Appeal Decision

Appeal Ref: APP/R5510/W/23/3335511

47 Fairfield Road, Hillingdon, Uxbridge UB8 1AZ

Basement Floor as Proposed

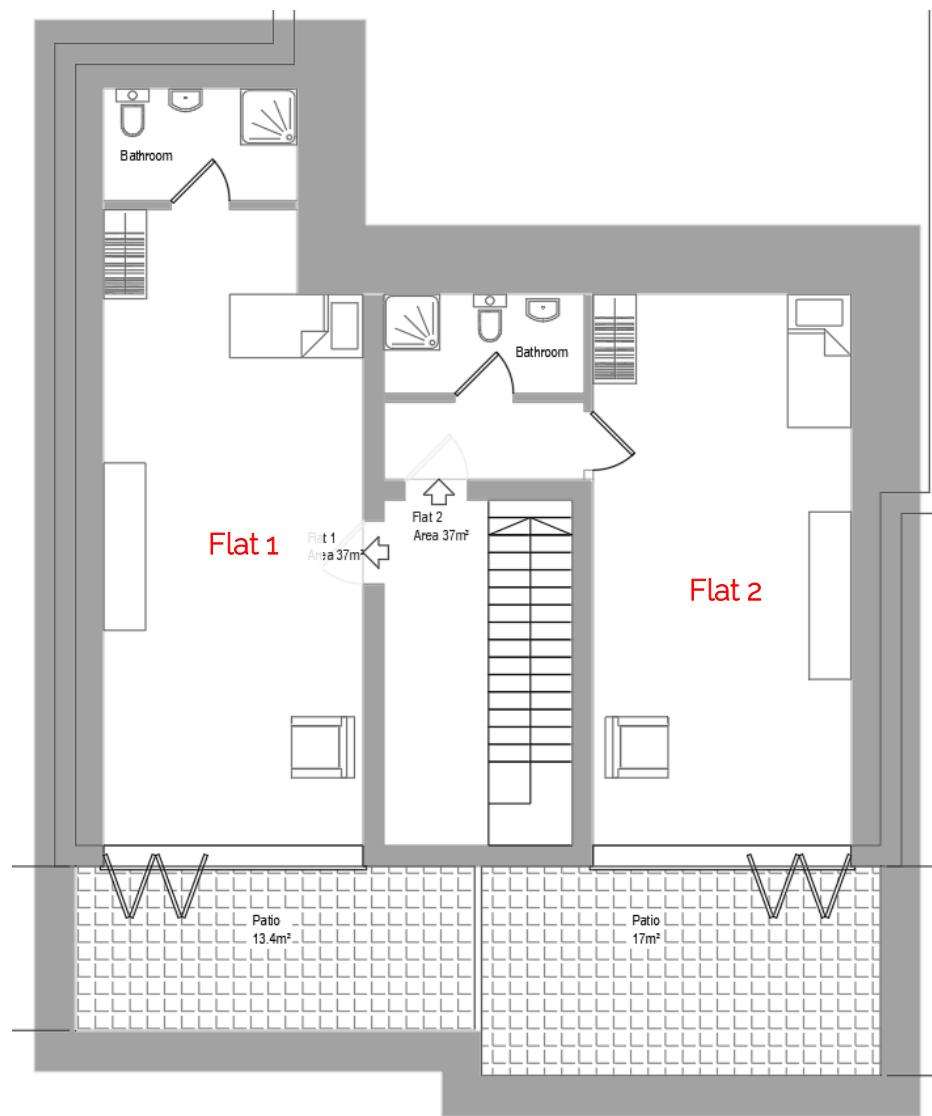
8. An Internal Daylight Assessment dated October 2023, submitted in support of the application, concludes that the proposed properties would have adequate levels of daylight. A sunlight assessment is not included as part of this assessment.

9. The appellant asserts that as the proposed basement studios are north facing no sunlight assessment is required. However, Policy D6 of the London Plan 2021 (LonP) requires the design of new development to provide sufficient levels of both daylight and sunlight. The sunlight passing through the bifold doors would be diminished due to the orientation of the building, which would face north-west, and the high retaining wall and railings surrounding the adjacent patio area. As such, the basement studios are likely to be gloomy and considerably less exposed to sunlight than the other properties proposed as part of the scheme.

10. Despite the increased depth of the sunken courtyards, the patio areas would extend to depths of around 2.35m for Flat 1 and around 3m for Flat 2. At such close proximity, the height of the retaining wall and railings would also result in an enclosed and poor outlook from within the studios. Those effects would result in an unsatisfactory internal living environment for the future occupiers of the studios.

11. Policy D6 of the LonP recognises the impact that a single aspect dwelling can have on living conditions in terms of ventilation and stipulates that they will only be acceptable when it has been demonstrated that it will have adequate passive ventilation. There is no exemption from this requirement for properties out with central areas. The proposed studios would be at lower ground level and, as detailed above, the opening would be enclosed by the retaining wall which would be likely to reduce airflow. I acknowledge that both studios would have a single large full height opening. However, there is no substantive technical evidence before me to demonstrate that sufficient passive ventilation can be achieved within the studio flats. As such I am not satisfied that the studios would provide a suitable standard of living in terms of ventilation.
